Natural England's Risk and Issues Log - Deadline 7 Submission.

The construction and operation of the Sheringham Shoal Extension and Dudgeon Extension Offshore Wind Farms located approximately 16km and 27km respectively from the Norfolk Coast in the Southern North Sea.

Planning Inspectorate Reference EN010109

10th July 2023

Figure 1 The proposed initial 1km² (light blue polygon) native oyster restoration site search area and the indicative size of the 10,000m² restored reef (red square within blue polygon) in the north-western section of the CSCB MCZ

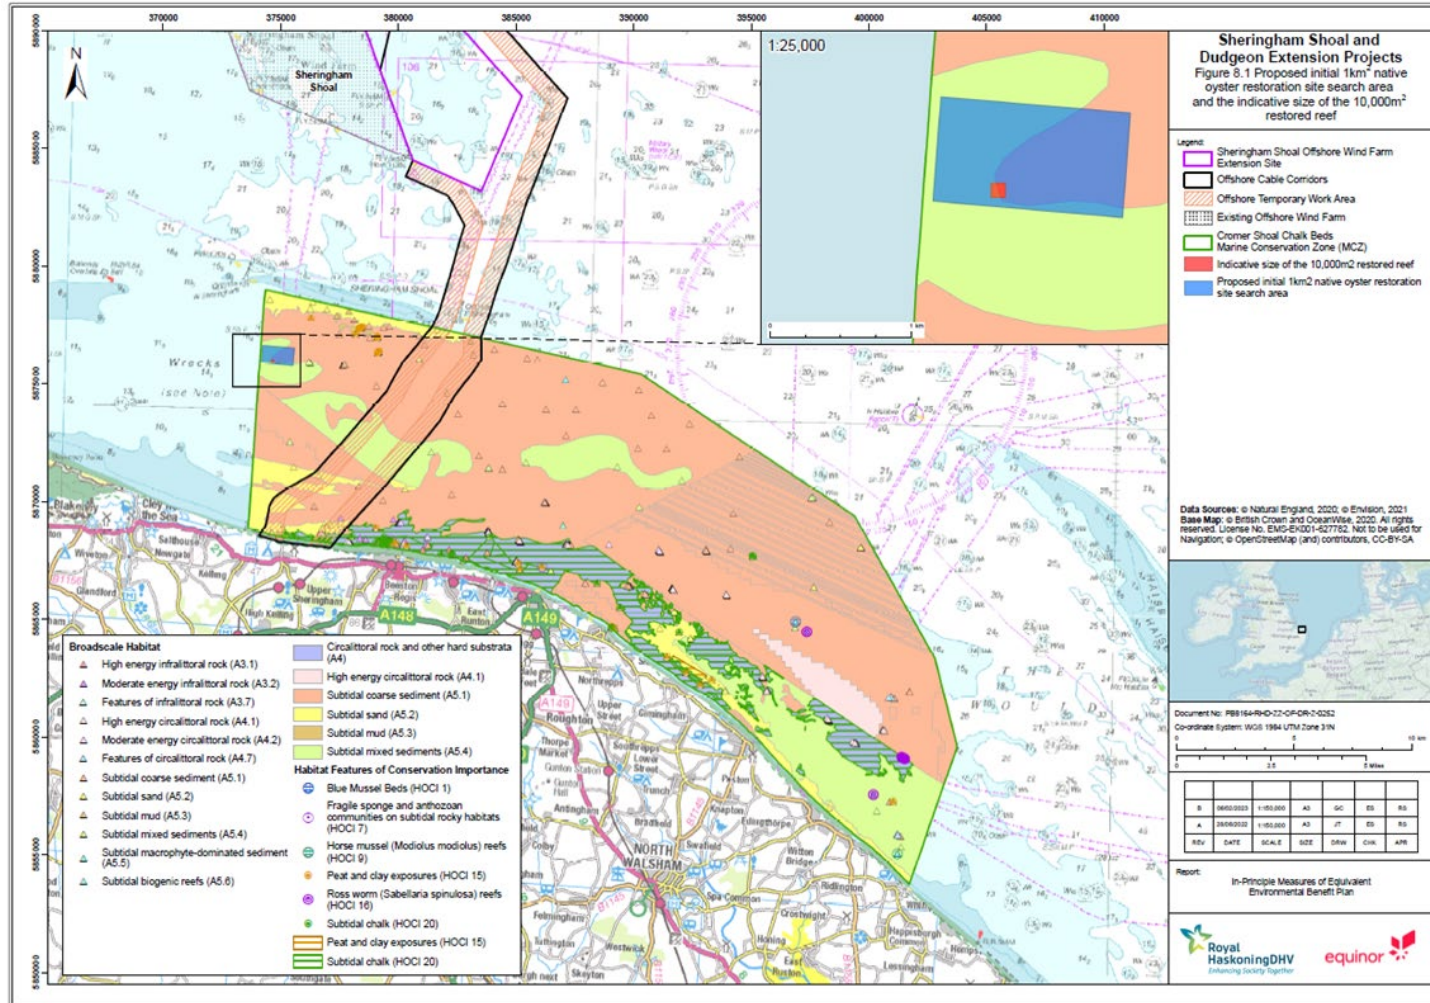
35	Natural England is supportive of the planting of native oysters as measures of equivalent environmental benefit (MEEB). However, we advise against the placement of clutch and restoration of an oyster bed in the middle of a mixed sediment area. For this to be considered as additionality, we advise that it would be better to extend/enhance the area of the mixed sediment on the boundary with impoverished coarse sediment e.g. in the centre of the 'c' shaped mixed sediment area or north/south of the blue rectangle.		Natural England supports the changes to address our concerns in relation to the location of the proposed Oyster Bed.							
36	Natural England highlights the need for the implementation of adaptive management measures should monitoring demonstrate the impacts are greater than predicted or unforeseen.		No change at Deadline 2.		No change at Deadline 3.		Please See Natural England's advice in Appendix A2. No change at Deadline 5.		No change at Deadline 7. Natural England understands the Applicant intends to submit an updated IPMP at Deadline 7.
